A1 in Northumberland: Morpeth to Ellingham

Scheme Number: TR010059

Summary of Proposed Changes to Application

Regulation Reference:	Infrastructure Planning (Examination Procedure) Rules 2010
Planning Inspectorate Scheme Reference	TR010059
Document Reference	TR010059/7.5
Author:	A1 in Northumberland: Morpeth to Ellingham Project Team, Highways England

Indicative Earthwork Change Locations

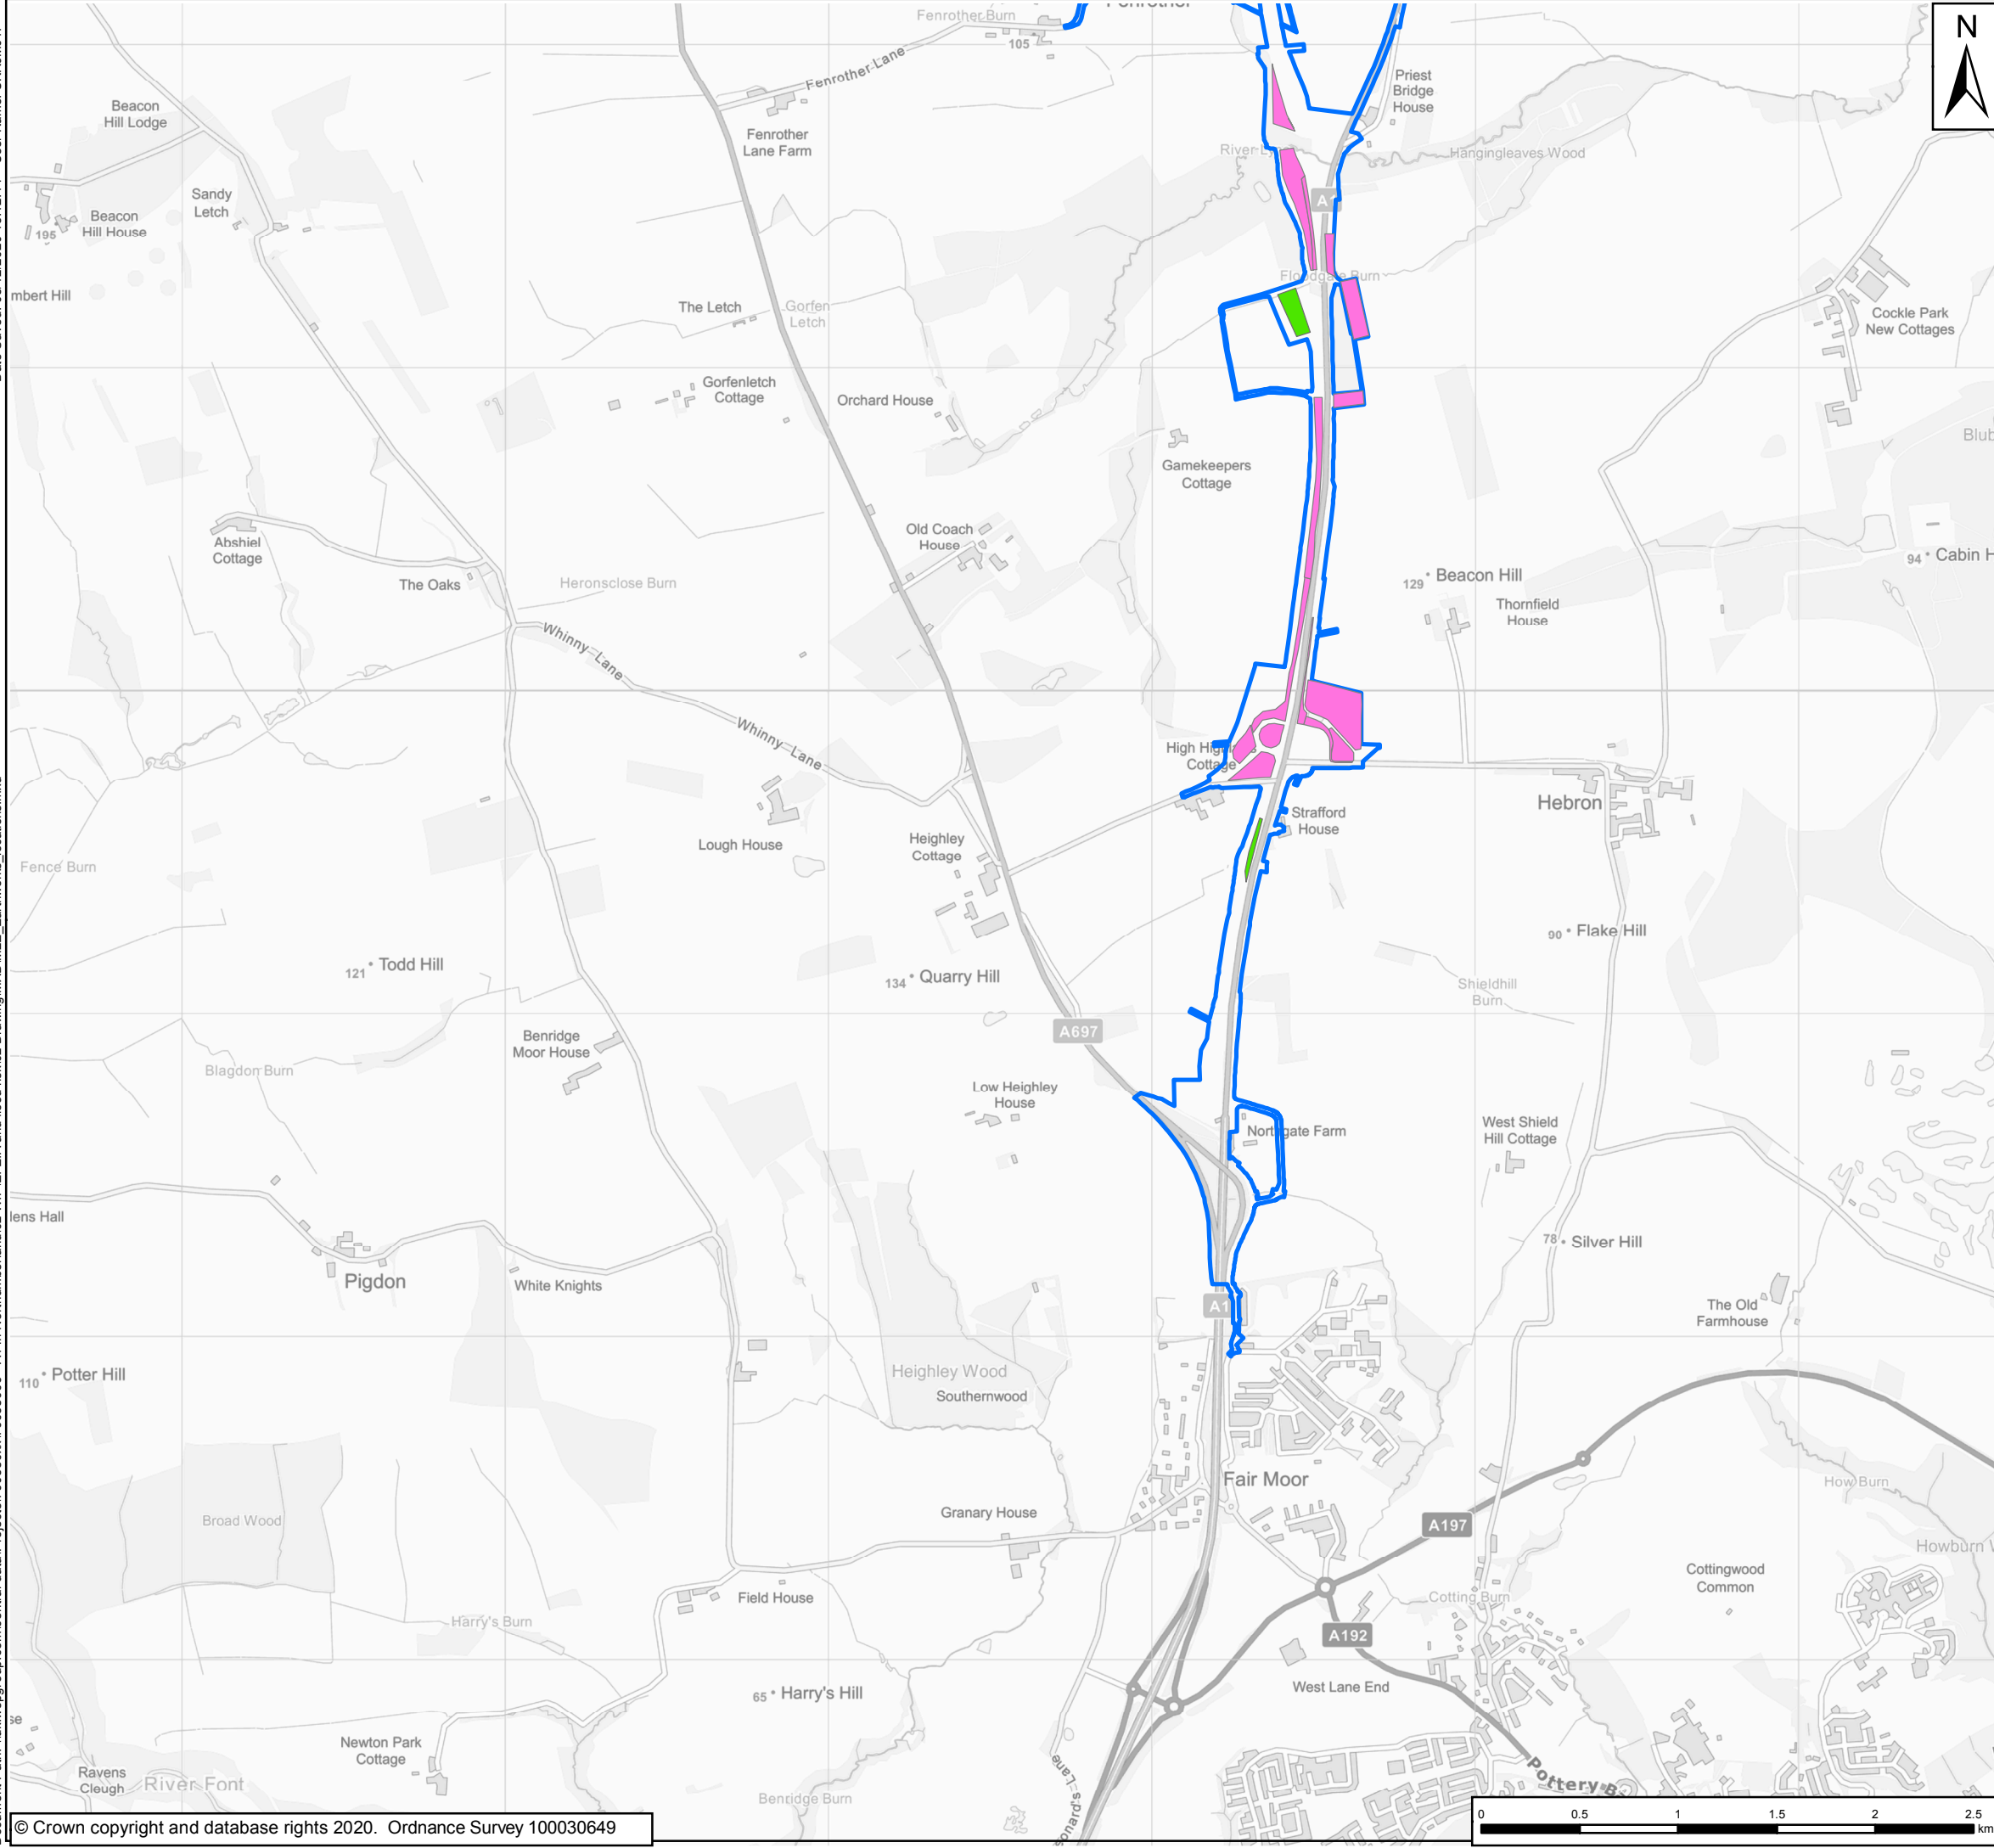
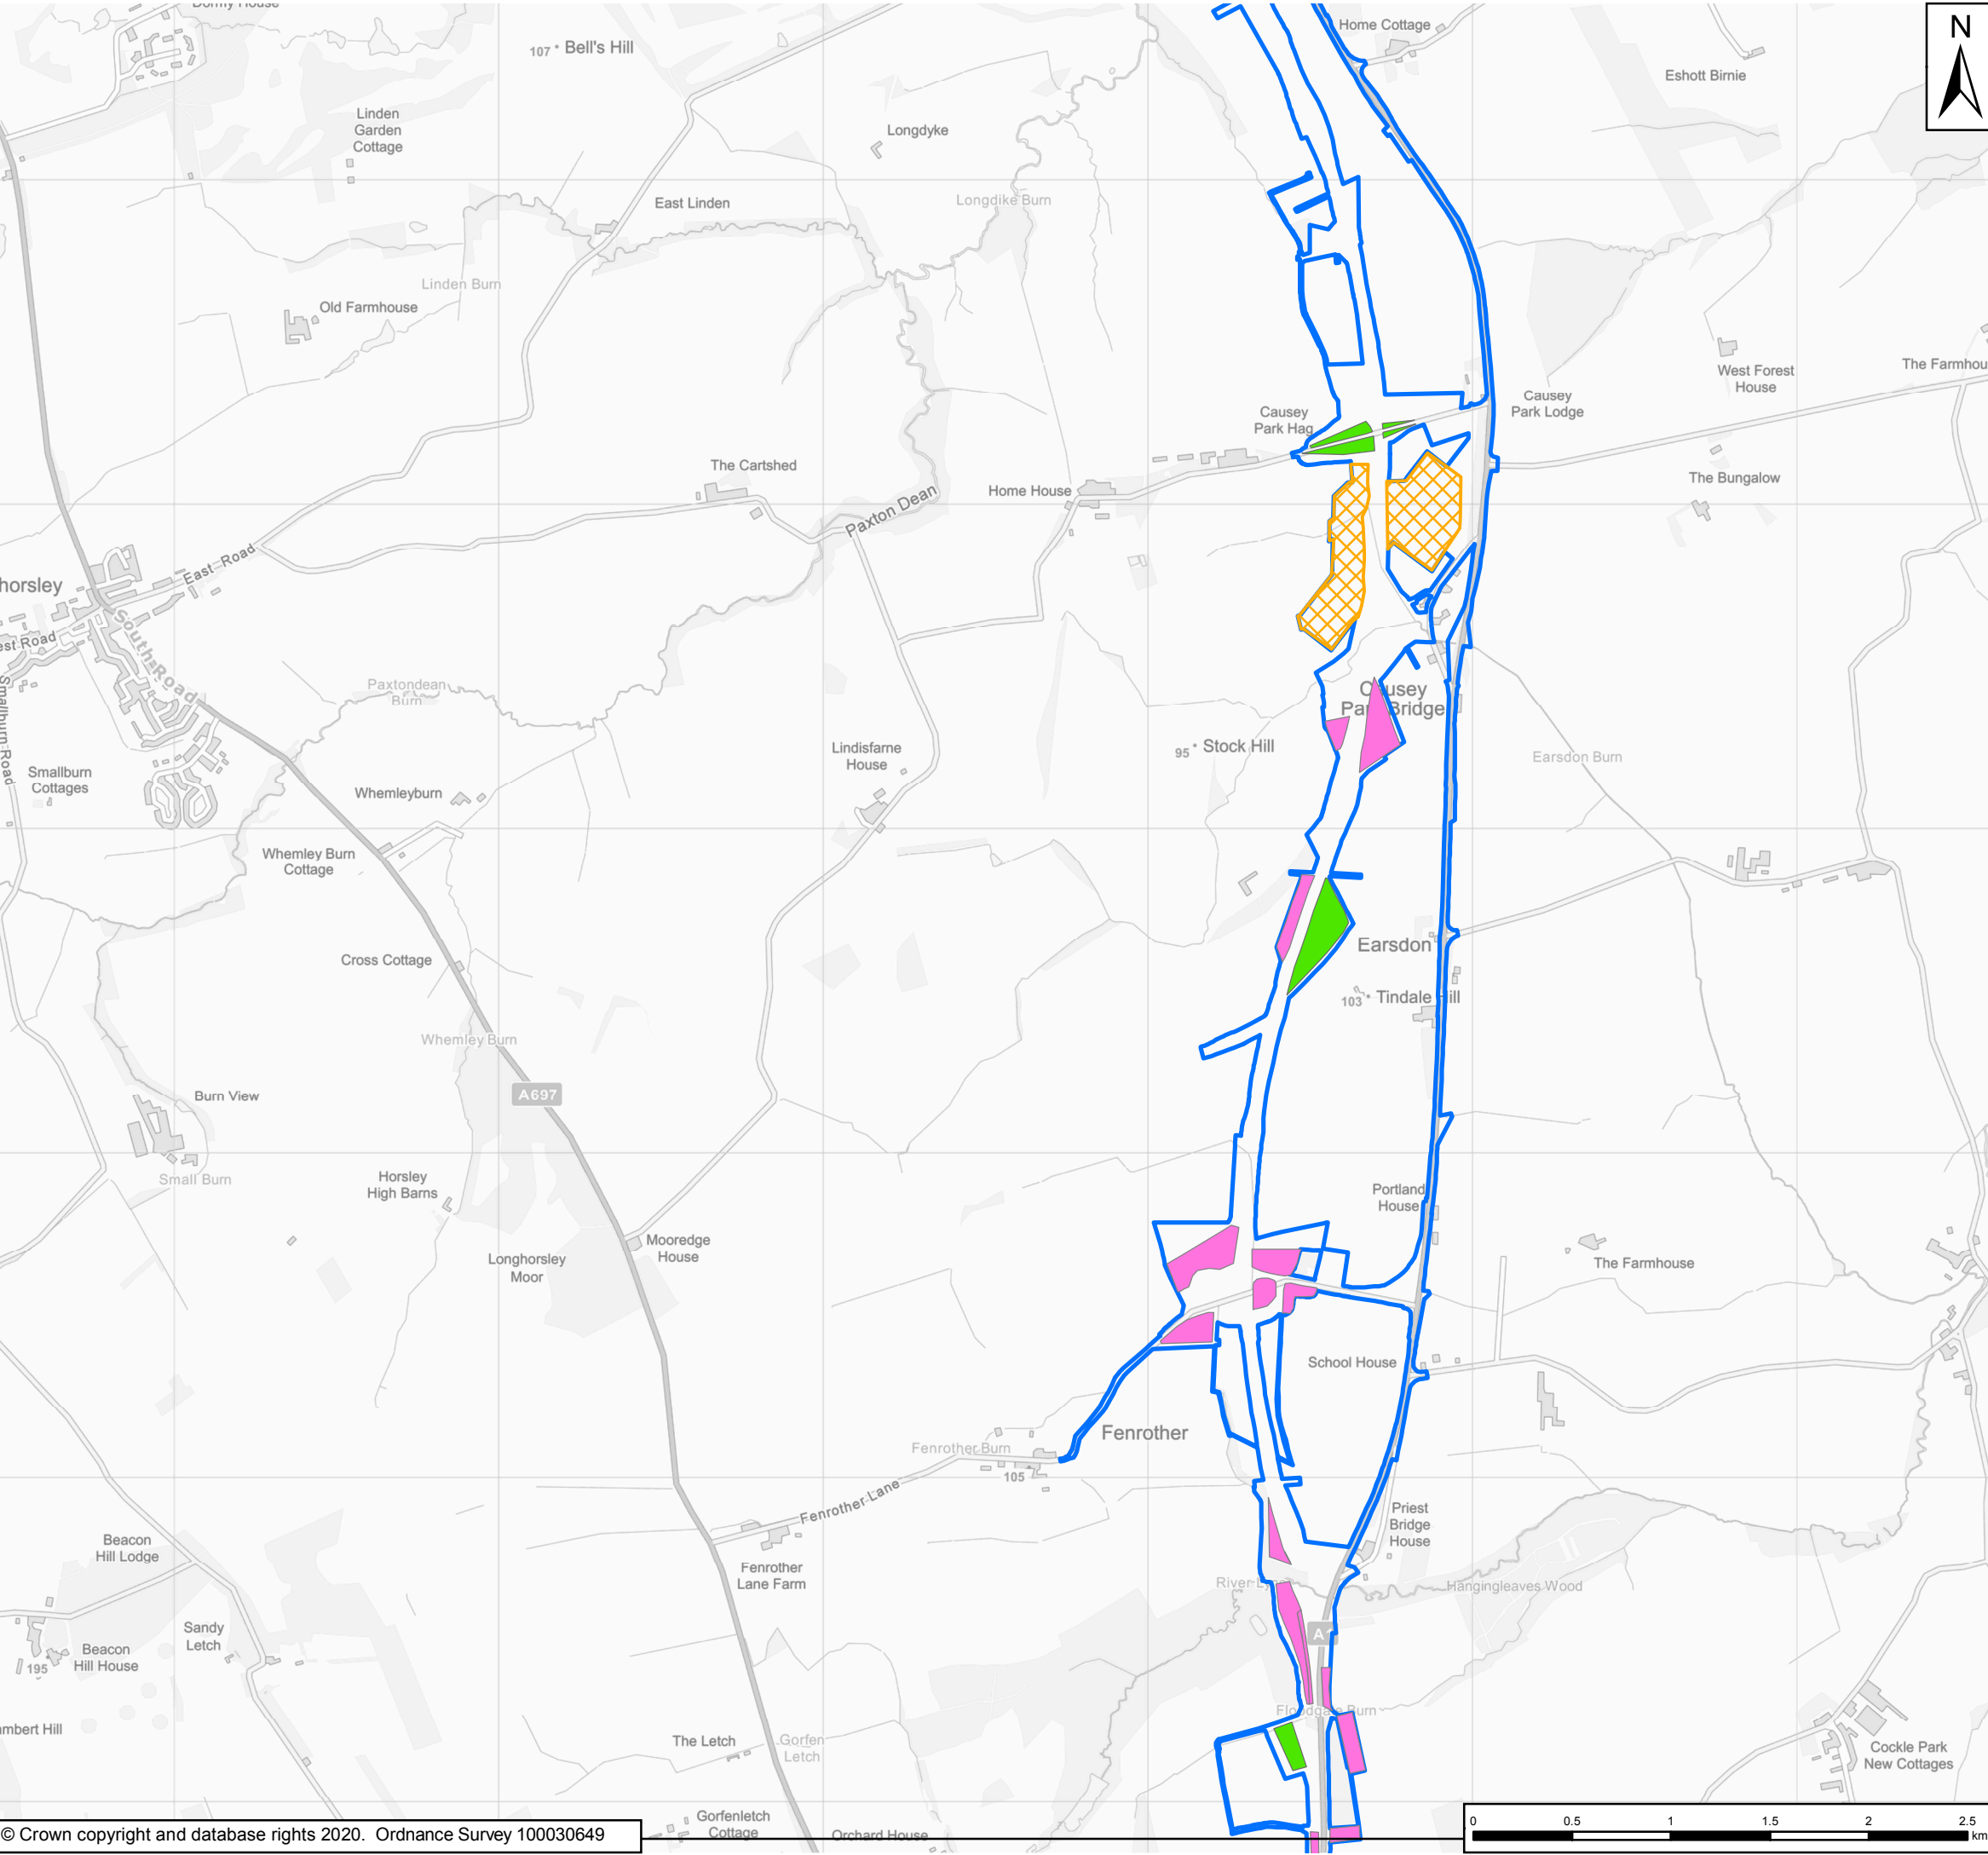
- 2.1.1 The Applicant proposes to maximise the re-use of materials (via excavation, deposition and temporary storage), within the existing Scheme extents. A recent review of the earthworks strategy has identified an opportunity to reduce earthwork movement and as a result greater flexibility in temporary and permanent storage of Site won material is required to achieve this. The indicative earthworks areas are shown in the figure in the **Indicative Earthwork Change Locations** figure in **Appendix A**.

- 2.1.2 To balance materials across both Parts A and B, the following methods are proposed:
- Utilising borrow pits to exchange and win additional material suitable for construction.

- Creation of new soil bunds within Part B to maximise re-use of excess site material.
 - Maximising of slopes for re-use of excess site material, in Part B.

- Laying down additional material increasing some localised ground levels.
 - Raising levels of junction “bowls” (level or rounded rather than dished).

- Creating new, temporary soil storage areas within both Part A and Part B.
- 2.1.3 These changes are an alteration to Parameters 4 and 5 for Part A, as set out in **Chapter 2: The Scheme** of the ES [APP-037]. There would also be additional temporary and permanent earthworks that require assessment for Part A and Part B. Therefore, it is appropriate to ensure that the environmental information before the Examination addresses the prospect of altered impacts This is addressed by sensitivity testing as described at **paragraph 2.1.6** below.
